WEST SUSSEX COUNTY COUNCIL CONSULTATION

TO:	Arun District Council FAO: Mr. S. Davis
FROM:	WSSC – Highway Authority
DATE:	21 January 2026
LOCATION:	Land adjacent to Woodgate Nurseries Lidsey Road, Aldingbourne, PO20 3SU
SUBJECT:	AL/1/26/DOC Approval of details reserved by condition imposed under AL/143/24/RES relating to condition 5-in-curtilage cycle storage for dwellings not provided with a communal store.
DATE OF SITE VISIT:	n/a (desktop study undertaken – site visited at outline stage)
RECOMMENDATION:	Advice

Cycle Storage Shed Specification Sheet

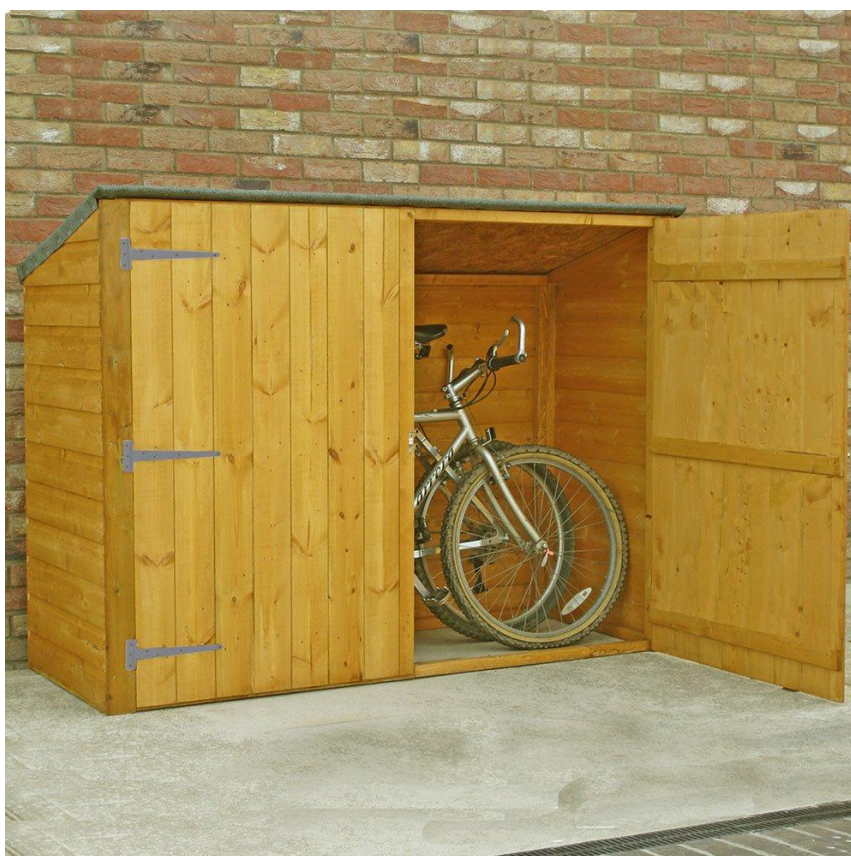
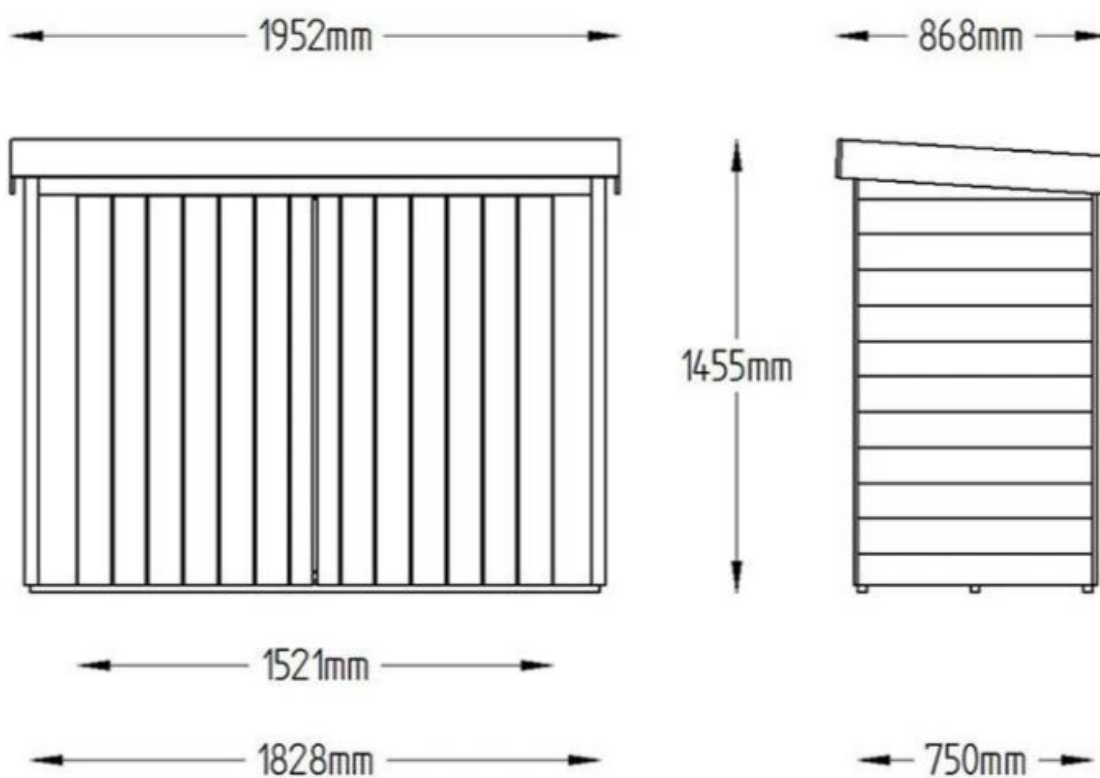
Arun District Council provides its own guidance for parking at new developments, although predominantly focuses on numbers of spaces rather than design thereof. As such, it should comment on that component of the submission. WSSC Highways has reviewed the type/design of provision offered (standalone storage sheds and garages) and locations thereof and these all appear to be reasonable and useable based on current guidance for such matters.
